Engineers Comments Regarding Surface Water Drainage

Application Reference:	A/20/26/DOC	Reviewer Reference:	ADC/EXT5/AF
Planning Officer:	Jessica Riches	Date of Review:	26/02/2026
Site Name:	Land North of Water Lane Angmering BN16 4EJ		
Application Description:	Approval of details reserved by condition under A/248/21/PL relating to condition 29 -As Built Drainage.		
Assessment Number:	1

Response	Condition 29: Further information required
-----------------	---

DITCH LONG SECTION

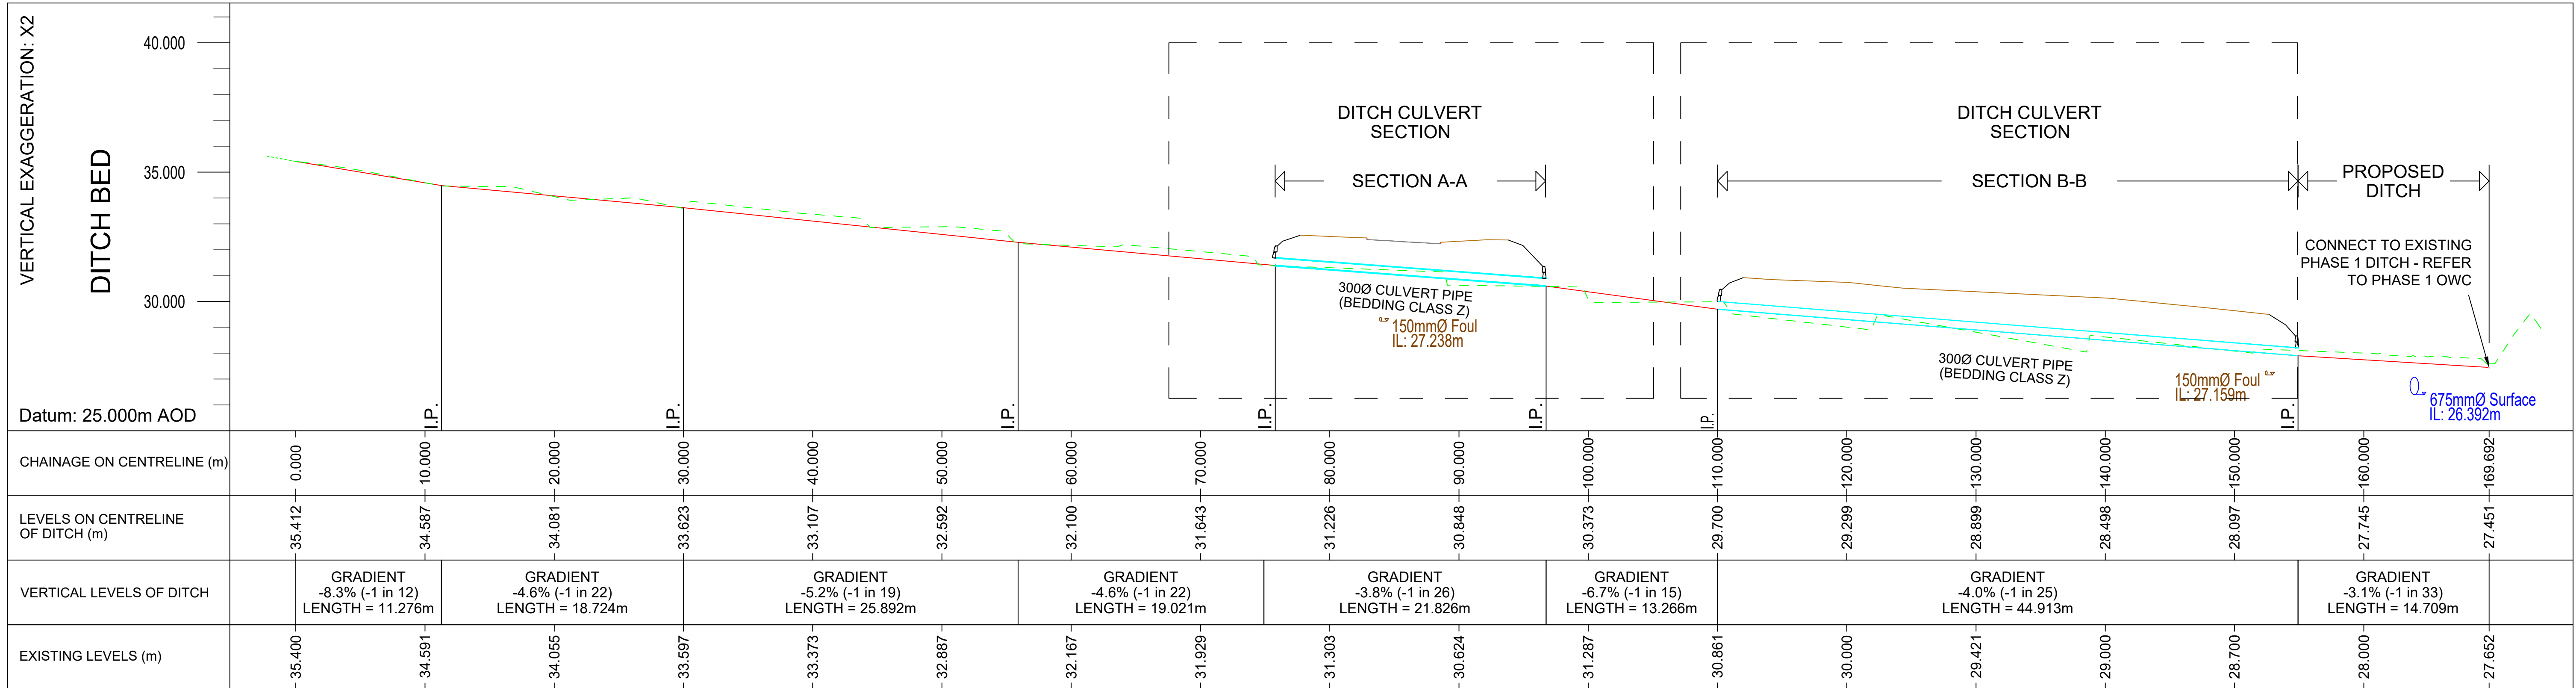
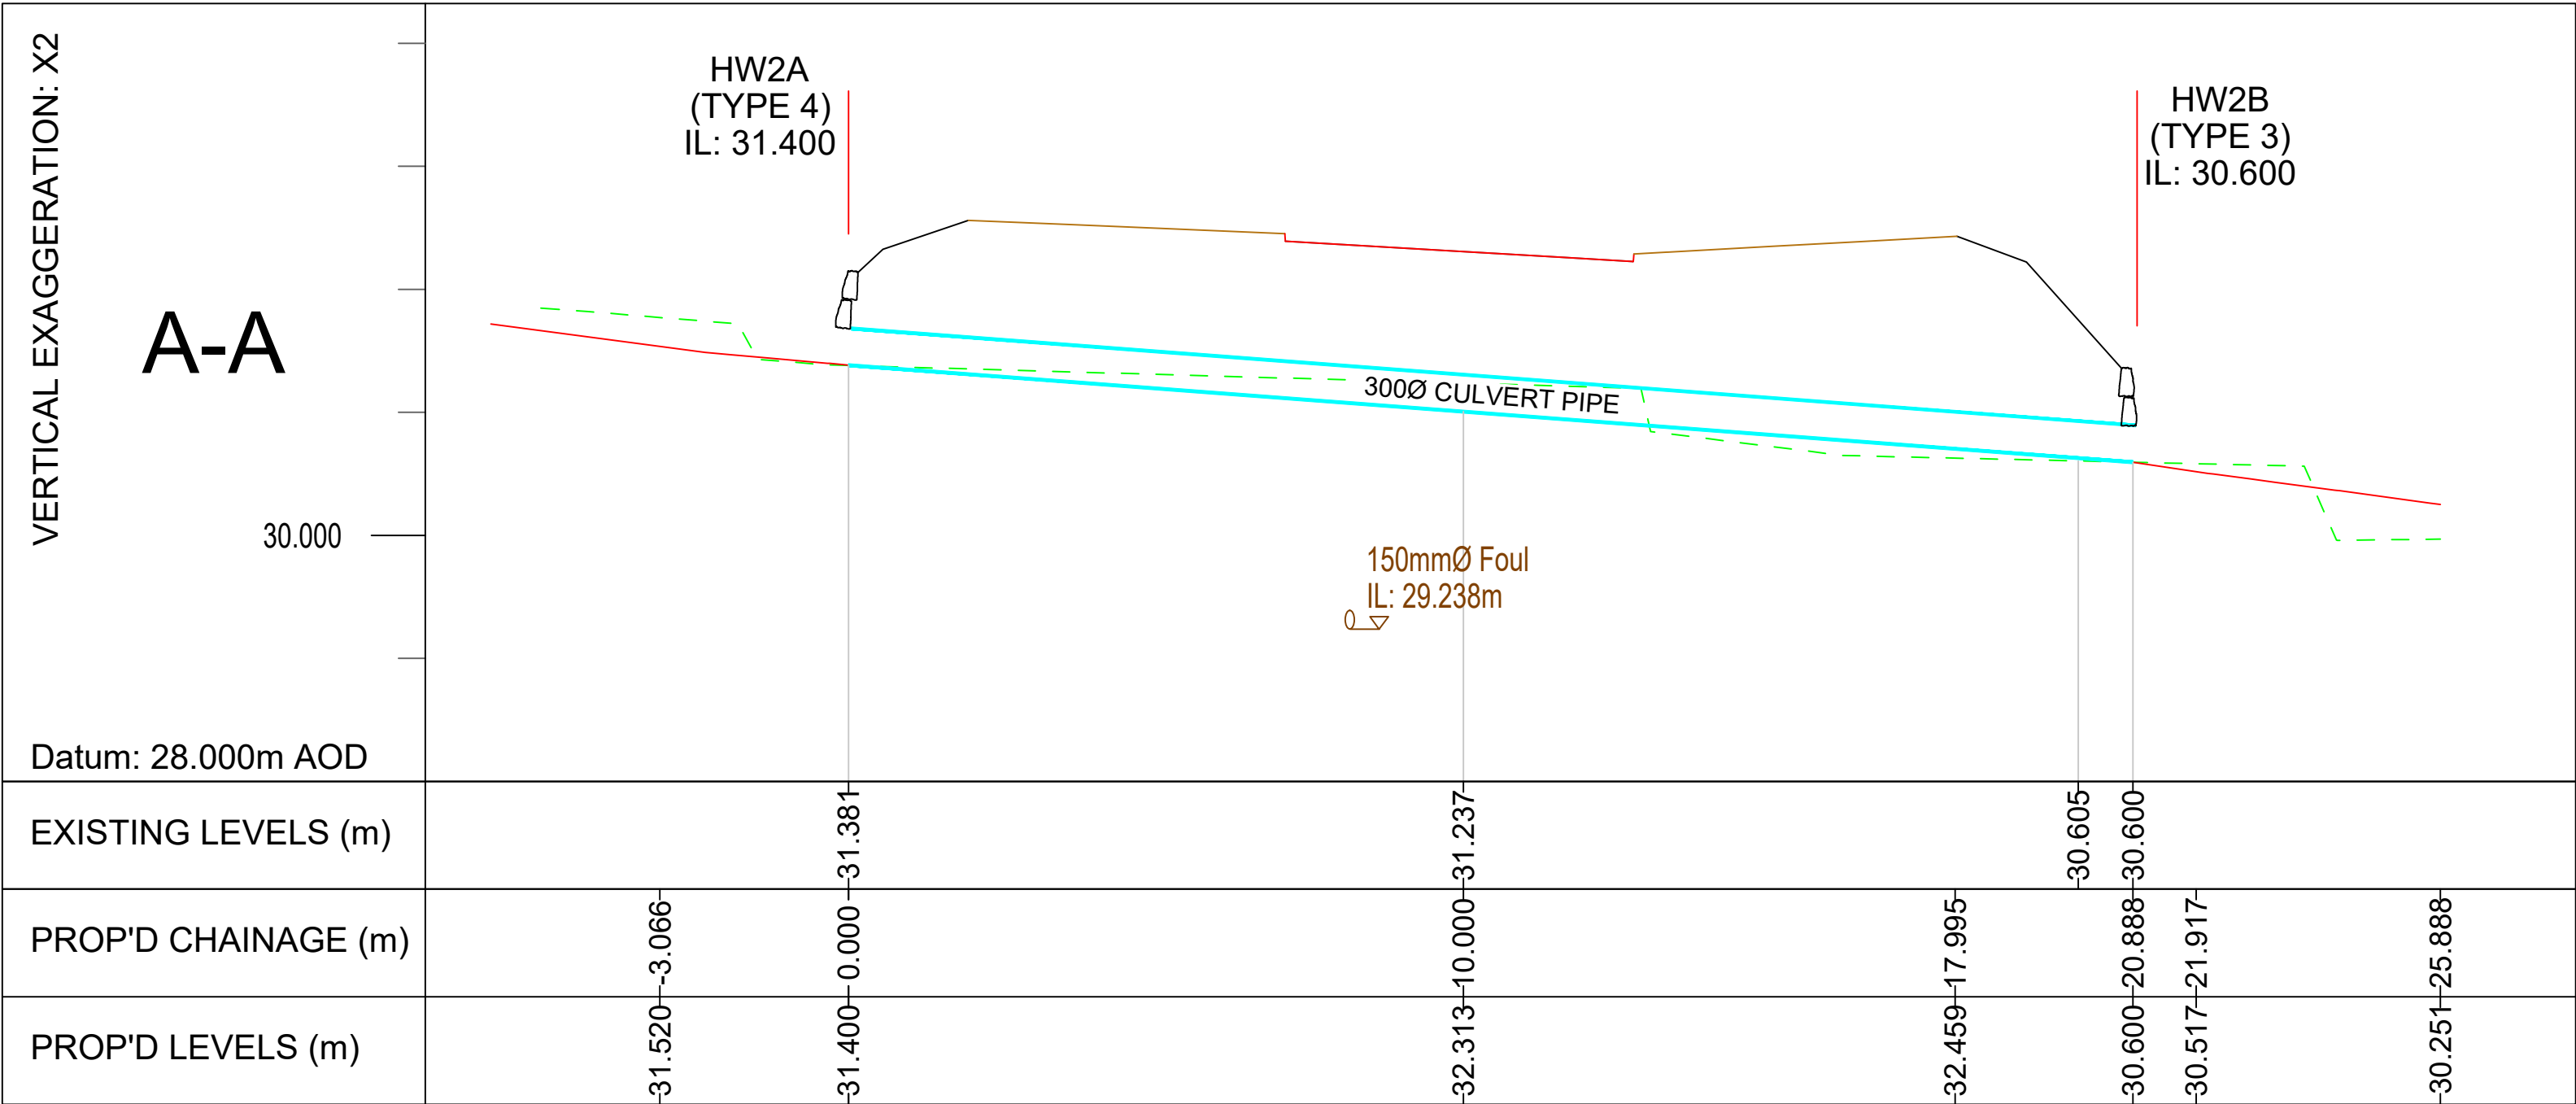
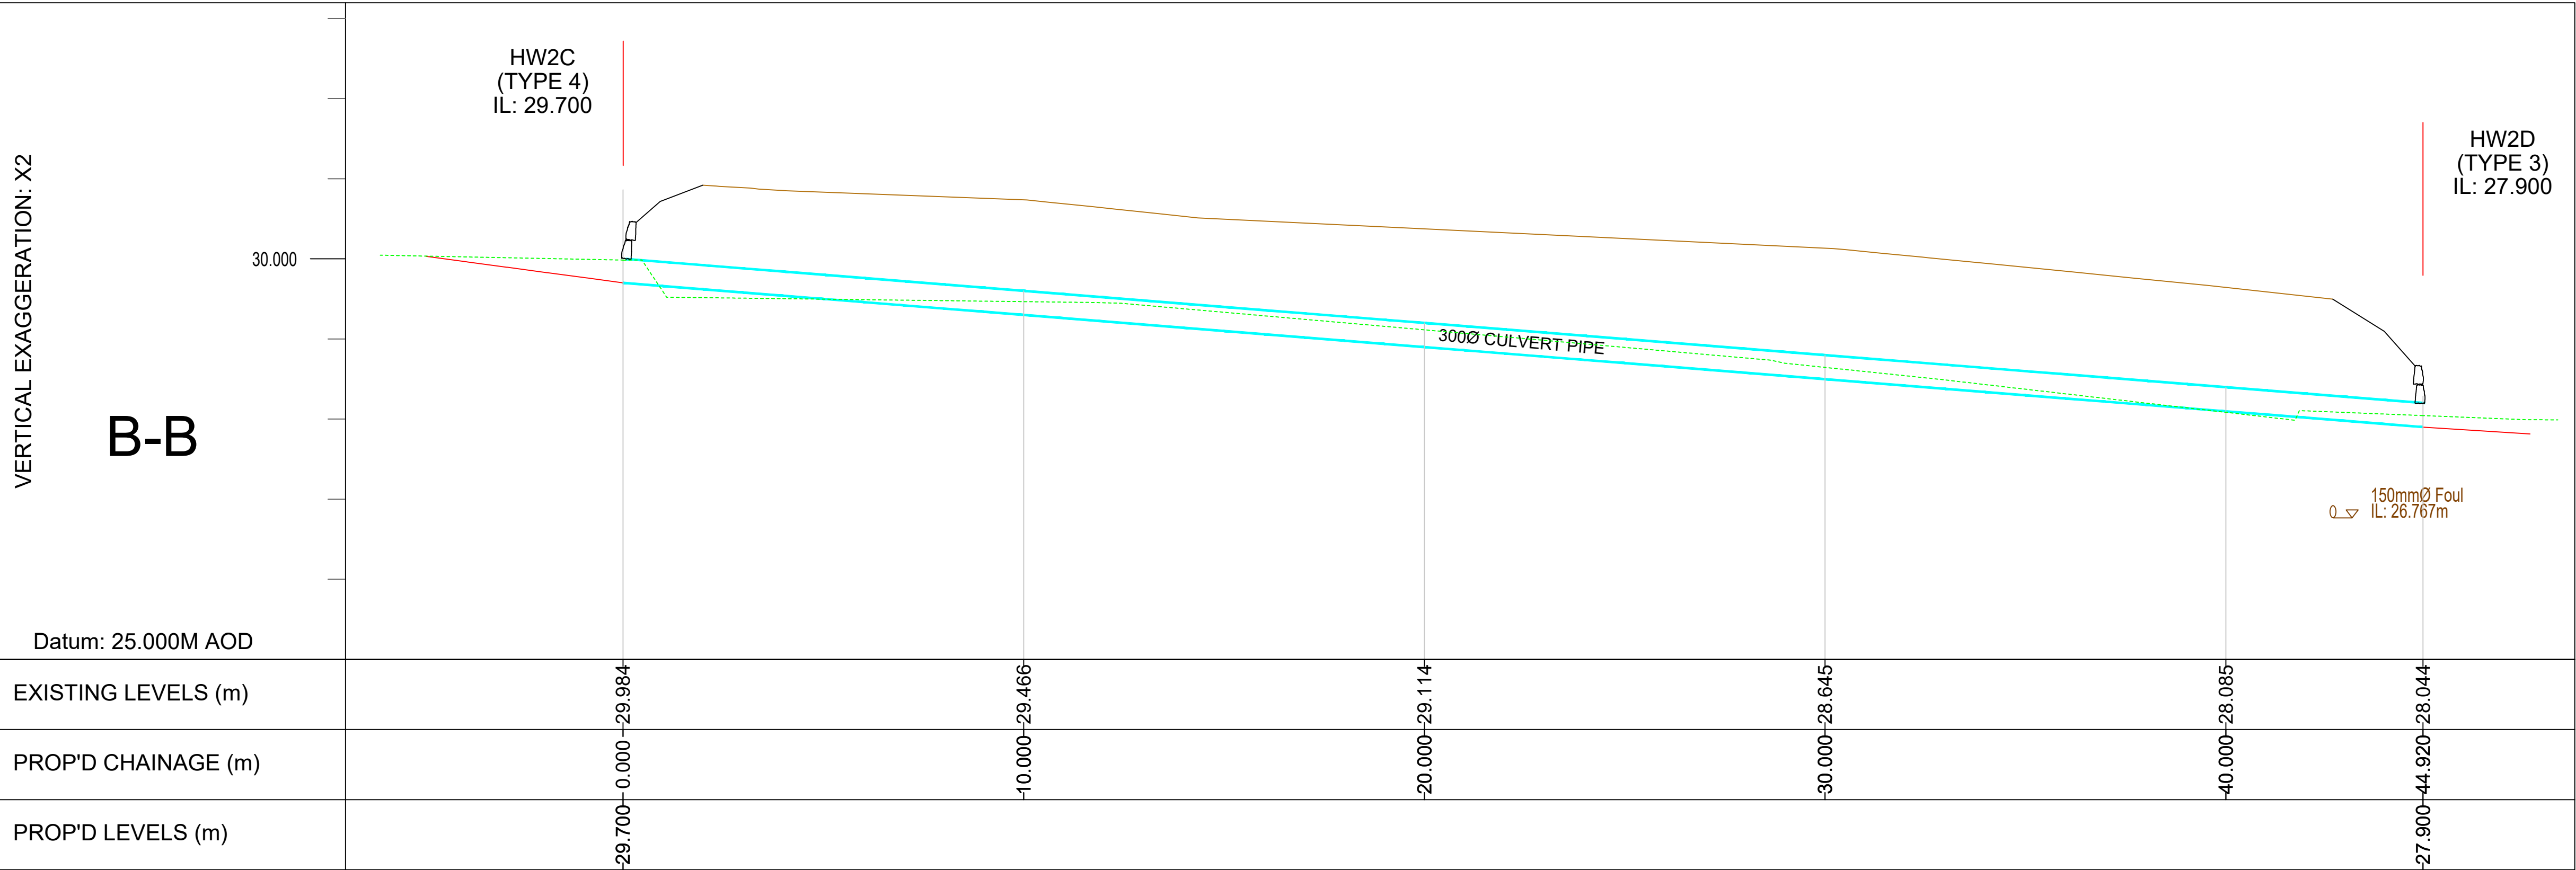
8.	S101 has an IL deviation of 344mm. Confirmation of no adverse effect on the functioning of the system is needed to support this change.				
9.	The alterations to Ordinary Watercourse should be evidenced within the report.
